**ADC Planning Consultation
Response from the Conservation Officer**

Application Number	BR/220/13/L
Address	Picturedrome Cinema 51 Canada Grove Bognor Regis PO21 1DW
Description	Application for Listed Building consent for the conversion of redundant space at first floor level to create Screen 3 seating up to 45 persons
Case Officer	Mr S Davis

DRAWING TITLE
DETAILED SECTION AND DETAILS OF WINDOW TREATMENT

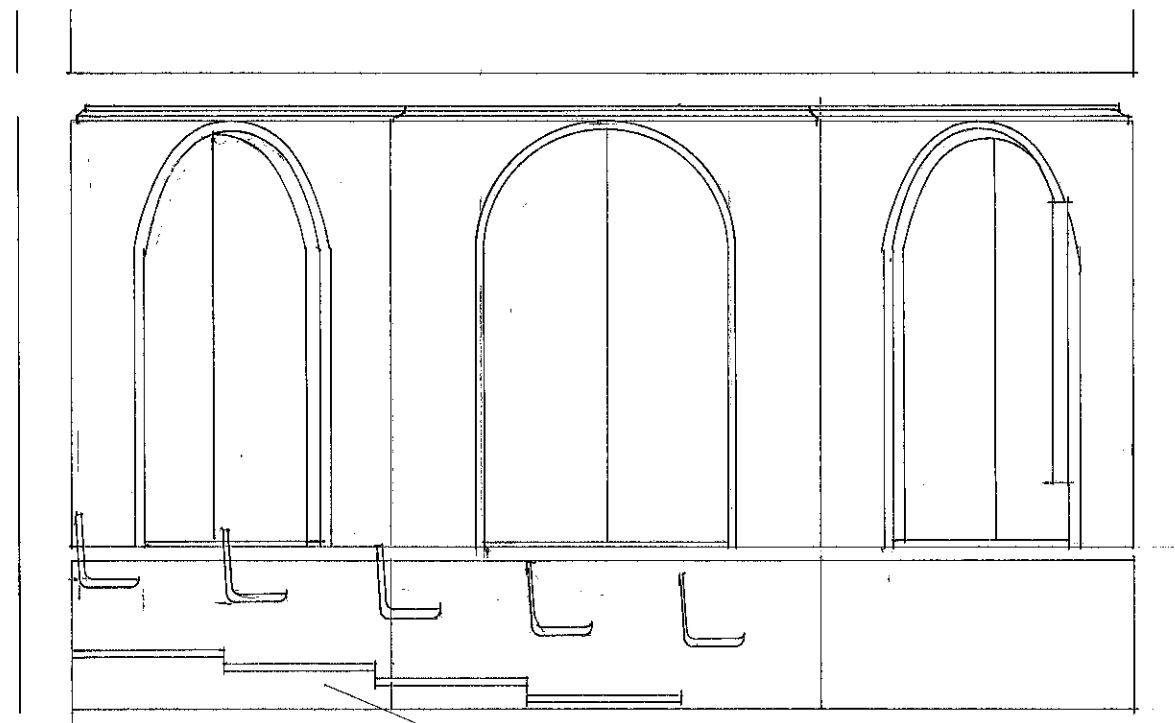
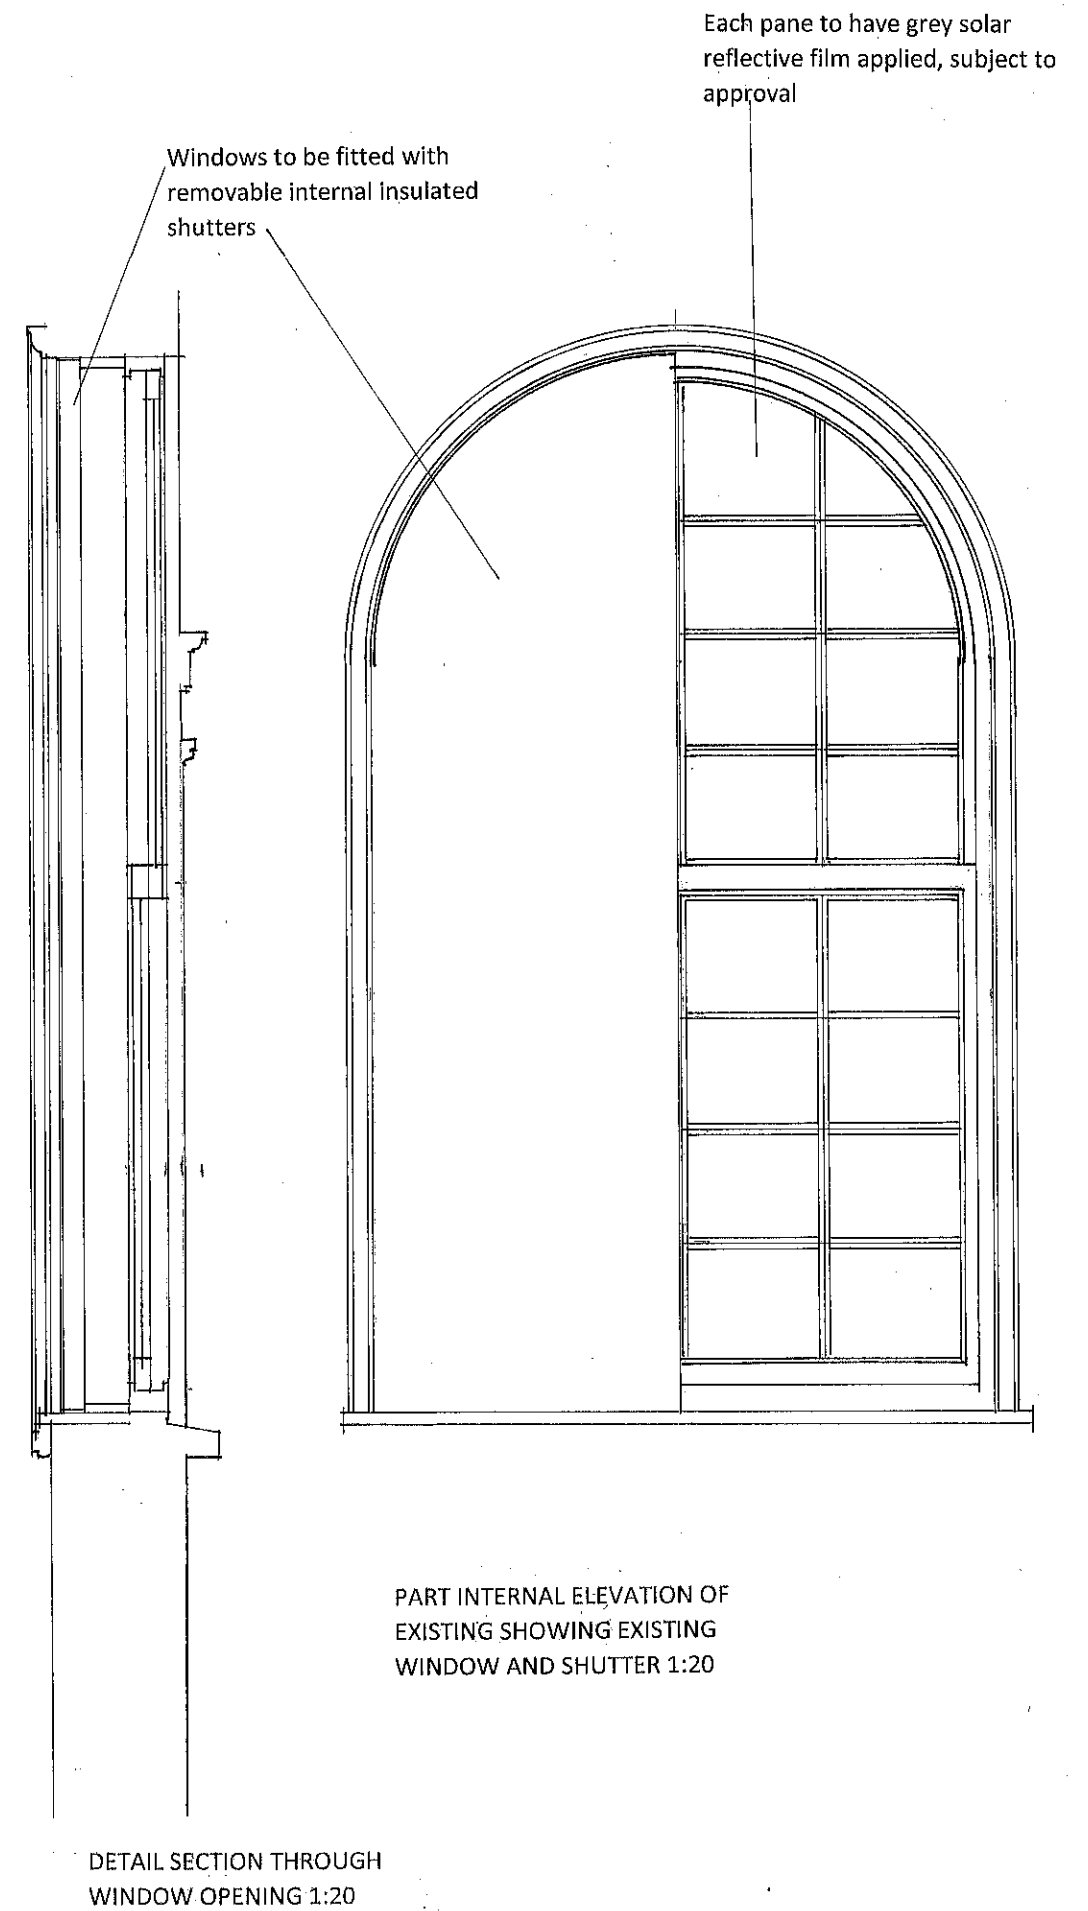
It is considered that the proposal will not have a detrimental impact on the character or appearance of the Conservation Area. However, it is considered that details of the film used to cover windows should be conditioned.

Details of film used to cover windows.
